From: carl@tonks-consulting.co.uk
To: [Metrowest1](#)
Cc: nigel.myres@coxauto.co.uk; Amy McCormack; "Christopher Burton"
Subject: MetroWest Phase 1 DCO TR040011 Closing
Date: 15 March 2021 18:07:01
Attachments: [c28b77bf.png](#)
[92e13839.png](#)
[cTc-2018-F-009 MetroWest DCO Hearing - Letter to PINS 15032021.pdf](#)

Our Ref. 2018-F-009
Date: 15th March 2021

MetroWest Phase 1 DCO
TR040011
Closing

2.47 - Ashton Vale Road and Winterstoke Road Highway Works Plan

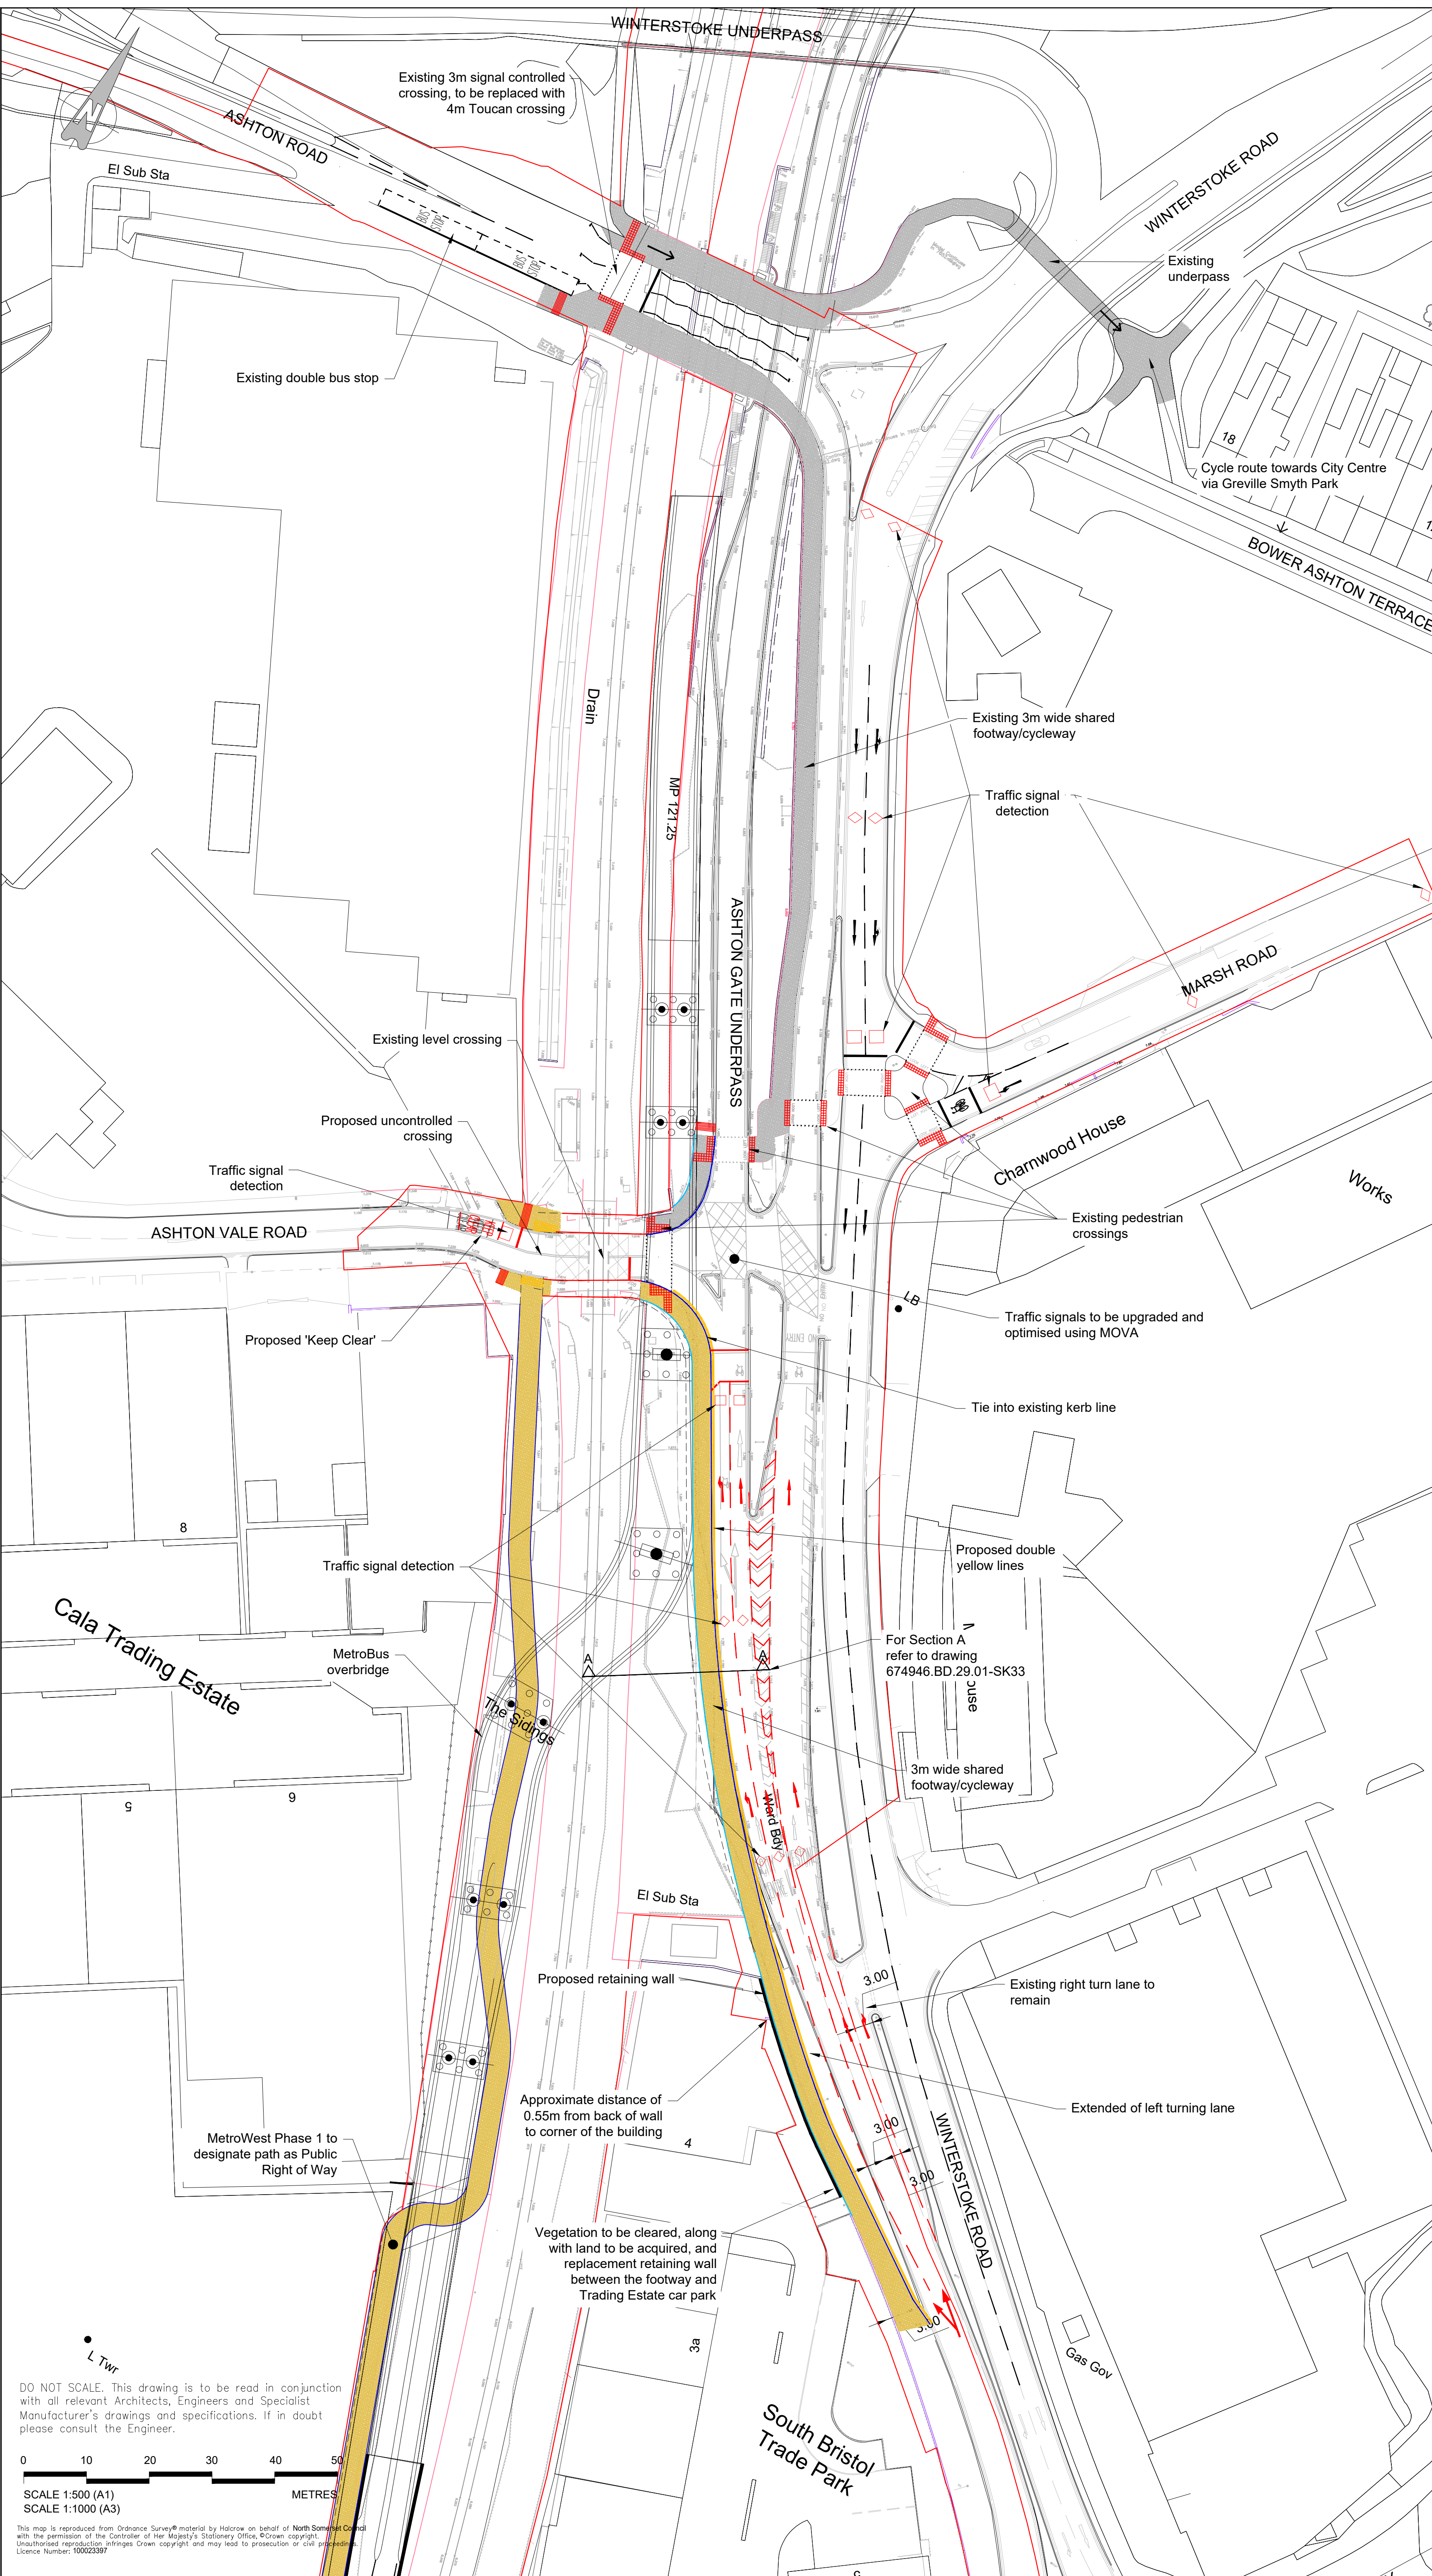
"Prior to the commencement of development the developer will submit a detailed design of the proposed junction of Winterstoke Road and Ashton Vale Road to include;

a, an extended left turn lane on Winterstoke Road for vehicles turning into the Ashton Vale Estate

b, Details of the MOVA traffic control measures proposed to achieve the no net detriment set out in [document x / TA]

c, Details of the regular monitoring of the MOVA traffic control measures proposed to ensure compliance with achieving the no net detriment as set out in [doc x / TA]

d, Methods for mitigating any breach of the requirements at b and c above

We believe the above is necessary in order to to ensure no adverse net impact on highway safety and transport movements at the junction between Winterstoke Road and Ashton Vale Road.
